KITTITAS COUNTY FIRE DISTRICT 2  
2020 Vantage Hwy  
Ellensburg WA 98926  
933-7232 (office) ☎ 933-7240 (fax)  
[kcfire2@elltel.net](mailto:kcfire2@elltel.net)

I have reviewed the Application for the Hatlestad Short Plat SP-06-113. I provide review of proposed development and construction for Kittitas County Fire District 2. The Fire District has no code enforcement authority so my input is, for the most part, informational only.

HATLESTAD SHORT PLAT
PART OF SECTION 16, T. 18 N., R. 18 E., W.M.
KITITAS COUNTY, WASHINGTON

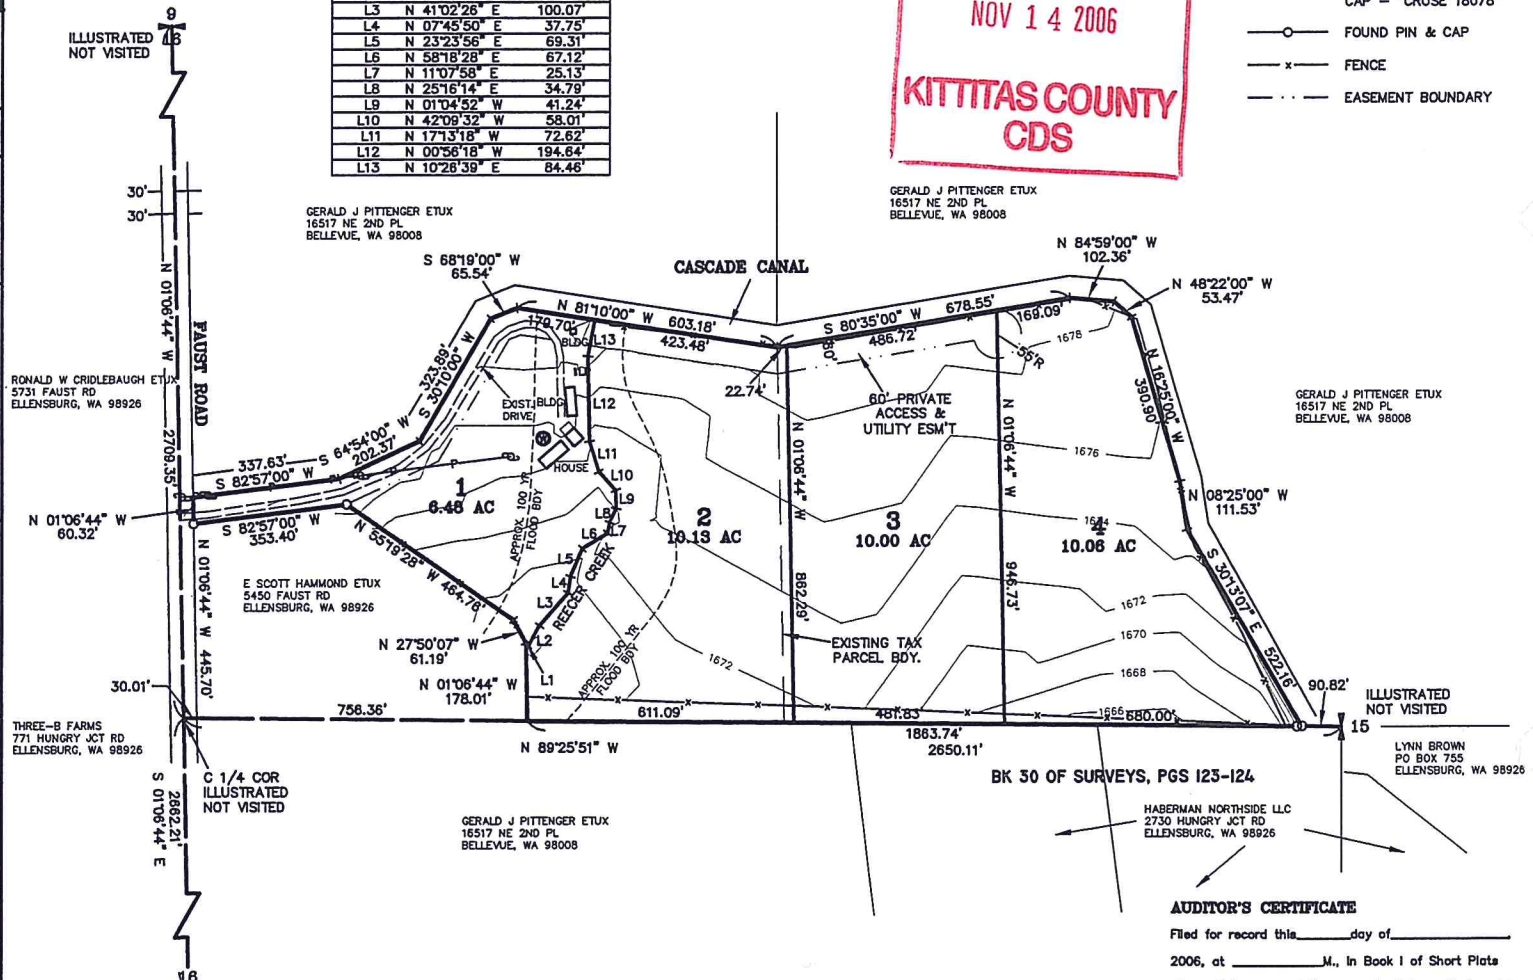
1. The addresses need to be clearly visible from both directions at the county road for all properties.
2. The fire department access road needs to be capable of supporting 75,000lbs in all weather, be 20' wide, provide 13'6" vertical clearance and provide for adequate turn-around for fire department apparatus in accordance with IFC 2003 – Appendix D.
